Our Ref: R/68/22/NMA

Non-material amendment following grant of R/258/21/HH for the addition of a window to the rear of the extension.

Mallondene 47 Mallon Dene Rustington BN16 2JP

P06 Proposed Floor Plans

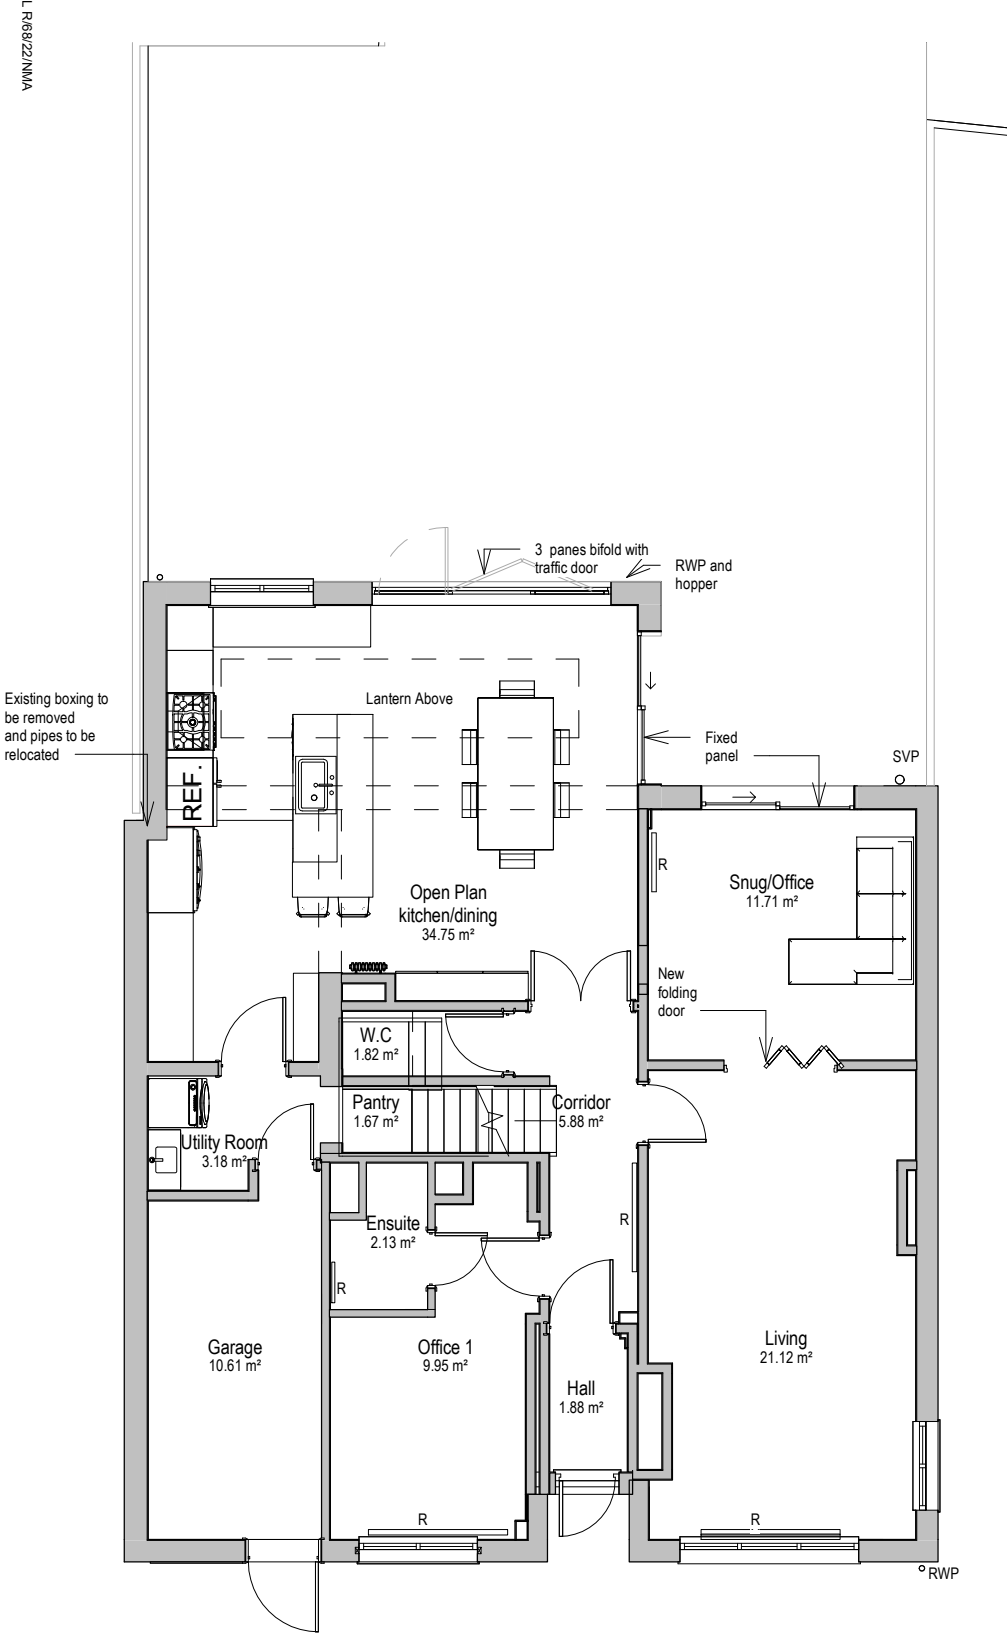
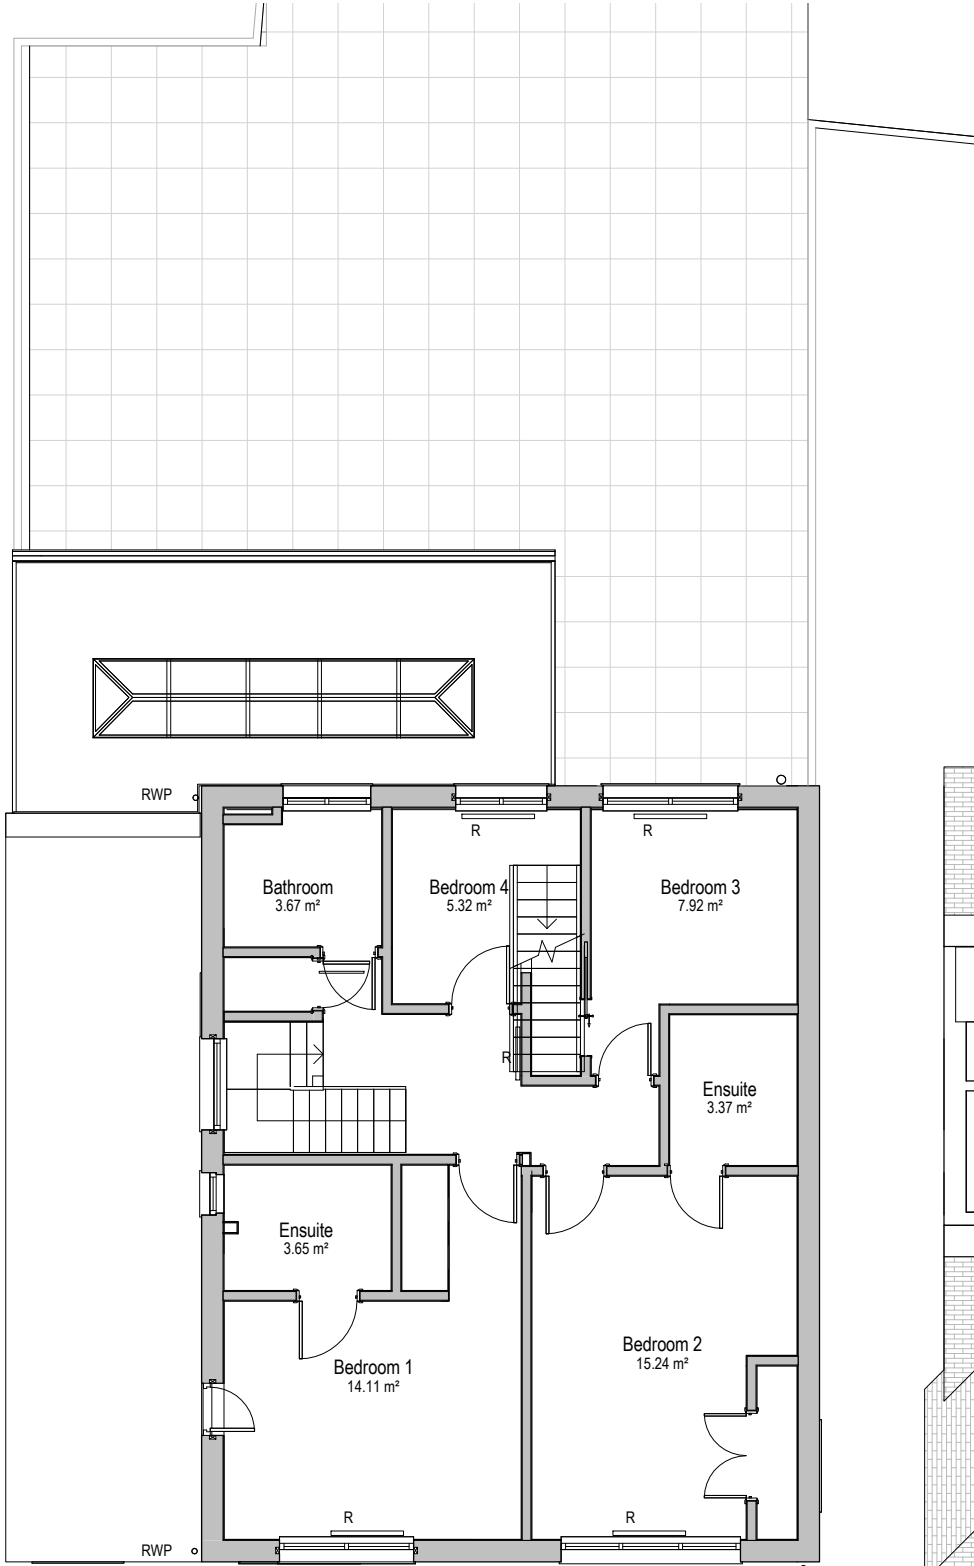
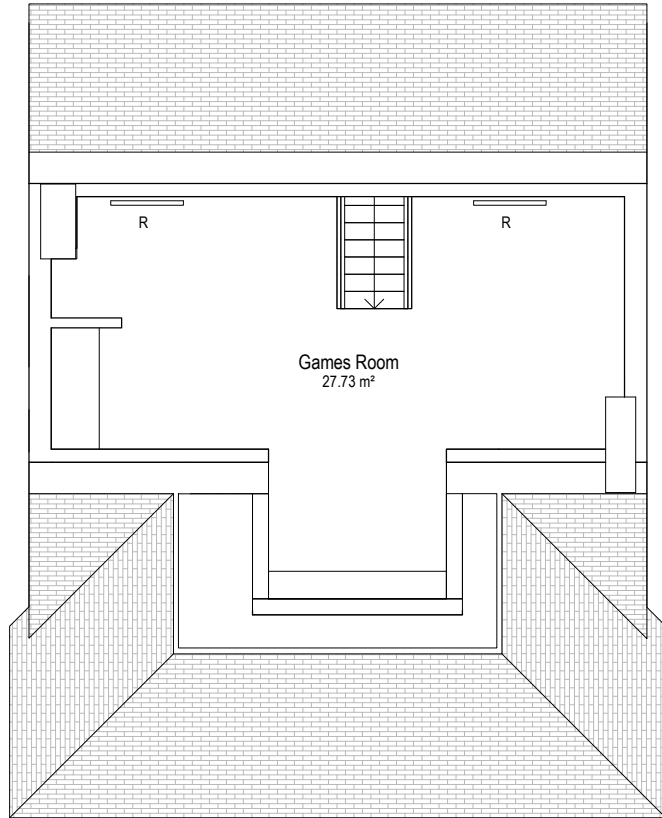
The reasons that these proposals have been accepted as Non-Material Amendments is because the window introduced does not give rise to any adverse impacts by way of overlooking onto neighbouring dwellings and it can therefore be considered under section 96A of the Town and Country Planning Act 1990.

- Proposed Elevations (Dwg No. P08, Rev. P3)
- Proposed Floor Plans (Dwg No. P06, Rev. P2)
